CITY OF ALBUQUERQUE

July 20, 2021

Re: Brewer Oil
3208 Richmond Drive NE
Traffic Circulation Layout
Architect's Stamp 06-01-2021 (H16-D095)

A1.1
TCL

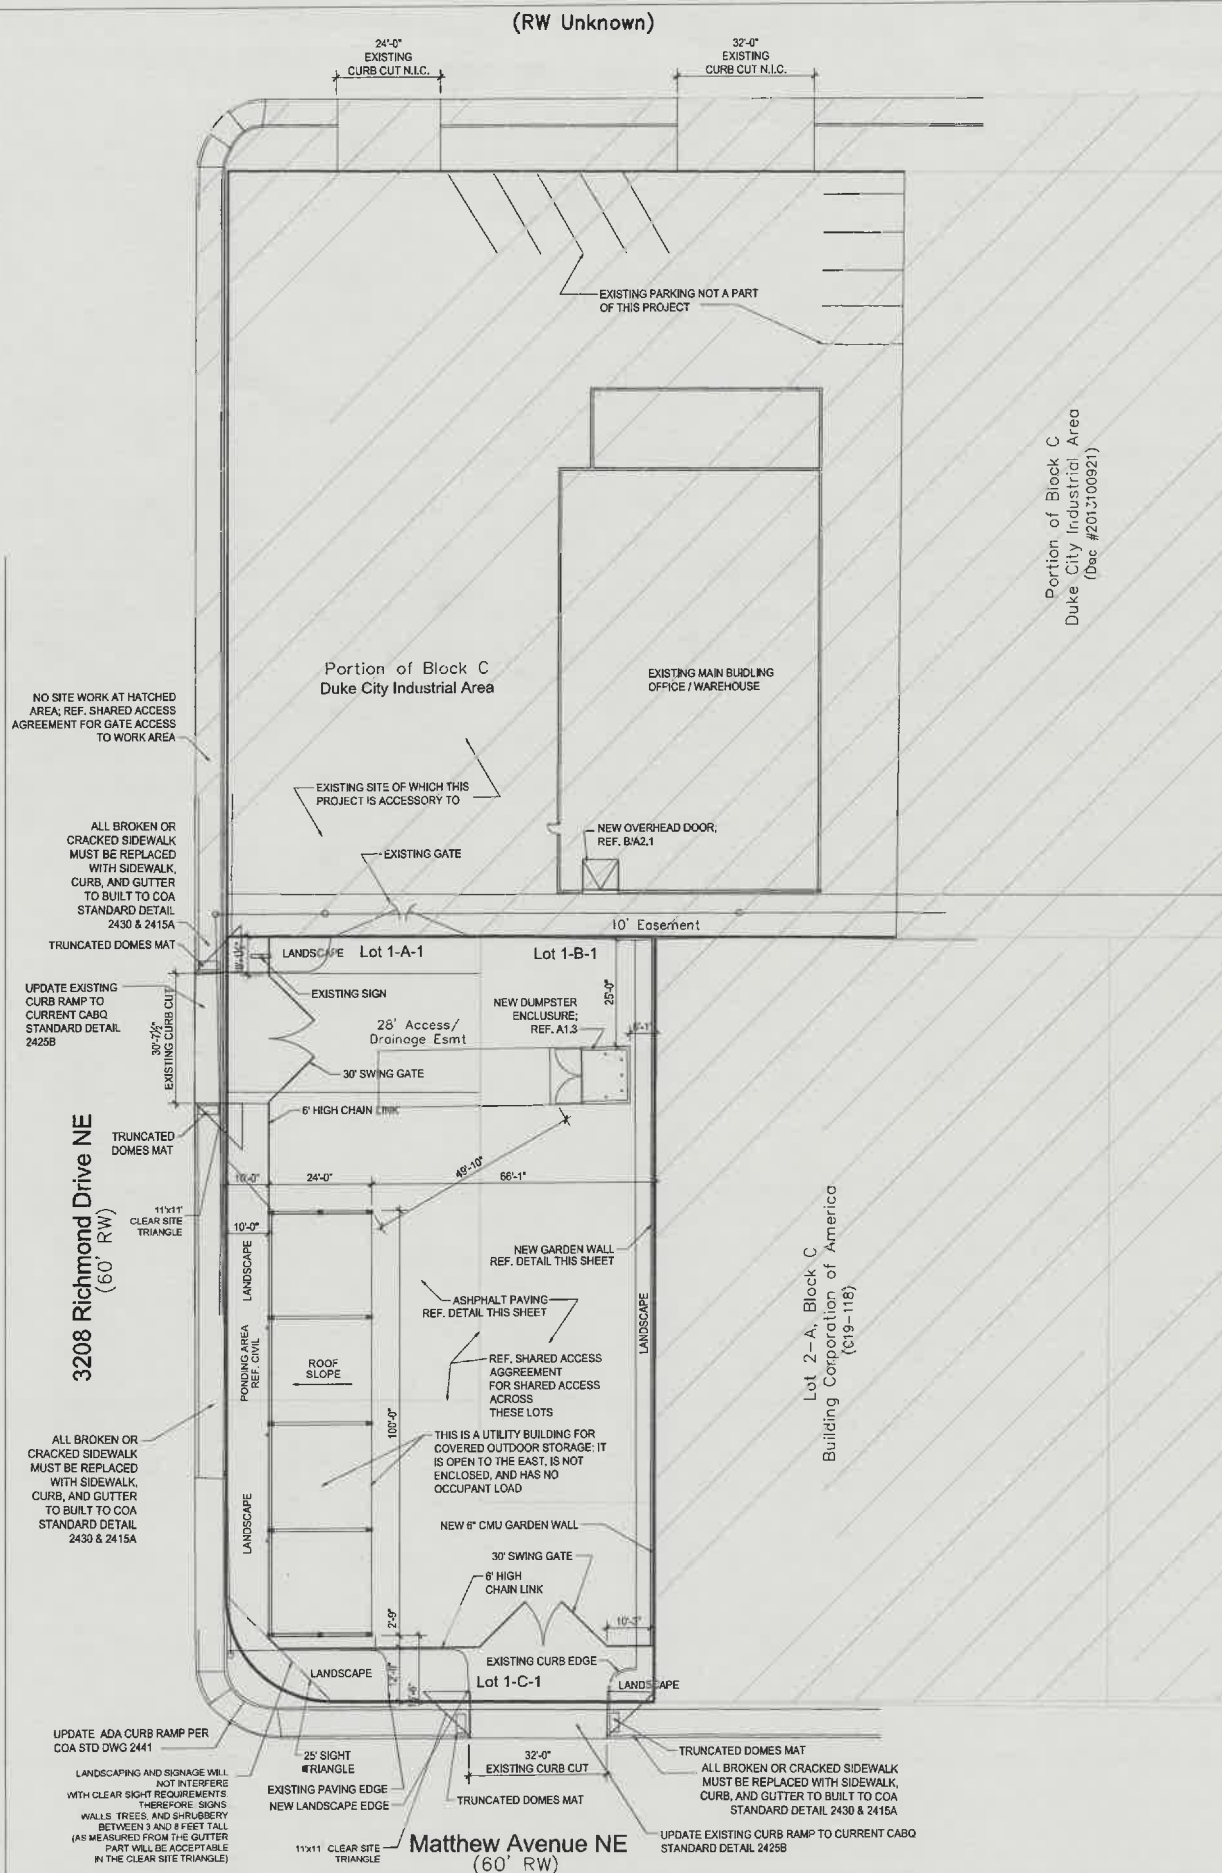
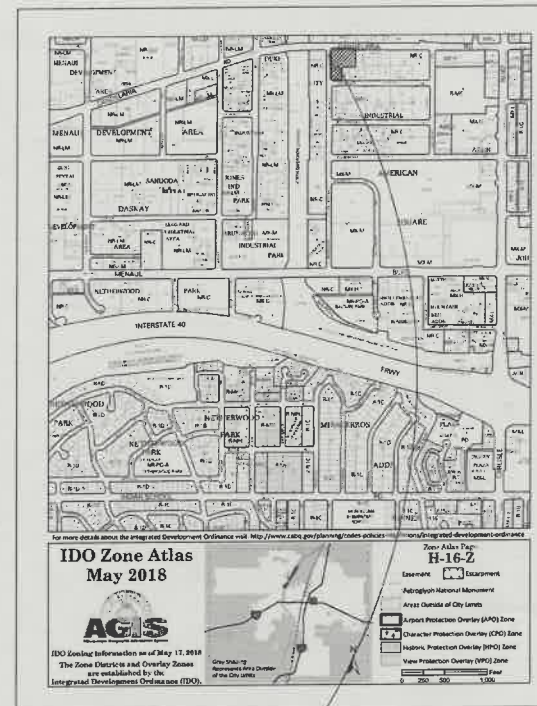
2. **All driveways and ramp along Candelaria and Richmond will need to be current/updated ADA accessible. Please identify this infrastructures and provide contruction notes on existing versus proposed or driveways that aren't ADA accessible will need to be replaced with ADA accessible driveways.**

3. **Ramp at corner of Candelaria/Richmond: It appears that the property line/private property encroaches into COA ROW. This encroachment will need a Sidewalk easement.**

4. Please identify all existing buildings, doors, structures, sidewalks, curbs, drive pads, wall and **anything that influences the parking and circulation on the site**. Is there adequate parking stalls to accommodate existing business?

5. Identify the right of way width, medians, curb cuts, and street widths on **Candelaria**.
6. Maximum access width for arterial, collector, and local streets are as follows:

7. **Please list the dimensions for all existing driveways, drive aisles . Some dimensions are not shown.**

12. **ADA curb ramps must be updated to current standards and have truncated domes installed. You are showing truncated domes on some of the driveways. Why?**

16. A 1-foot clear zone around the bicycle parking stall shall be provided.
17. Bicycle parking spaces shall be at least 6 feet long and 2 feet wide.
18. Show all drive aisle widths and radii. Some dimensions are not shown.

20. List radii for all curves shown; for passenger vehicles. Radius for delivery trucks, fire trucks, etc. is 25 ft. or larger.
21. Per the IDO, a 6 ft. wide ADA accessible pedestrian pathway is required from the public sidewalk to the building entrances. Please clearly show this pathway and provide details.

22. Per DPM, a 6 ft. wide ADA accessible pedestrian pathway is required from the ADA parking stall access aisles to the building entrances. Please clearly show this pathway and provide details.

24. **Provide a copy of refuse approval.**
25. **Please provide a sight distance exhibit (11 FT X 11 FT on driveways)**
26. **Show the clear sight triangle and add the following note to the plan: "Landscaping and signage will not interfere with clear sight requirements. Therefore, signs, walls, trees, and shrubbery between 3 and 8 feet tall (as measured from the gutter pan) will not be acceptable in the clear sight triangle."**

29. Add a note stating **"All broken or cracked sidewalk must be replaced with sidewalk and curb & gutter."** A build note must be provided referring to the appropriate City Standard drawings (**2430 & 2415**).
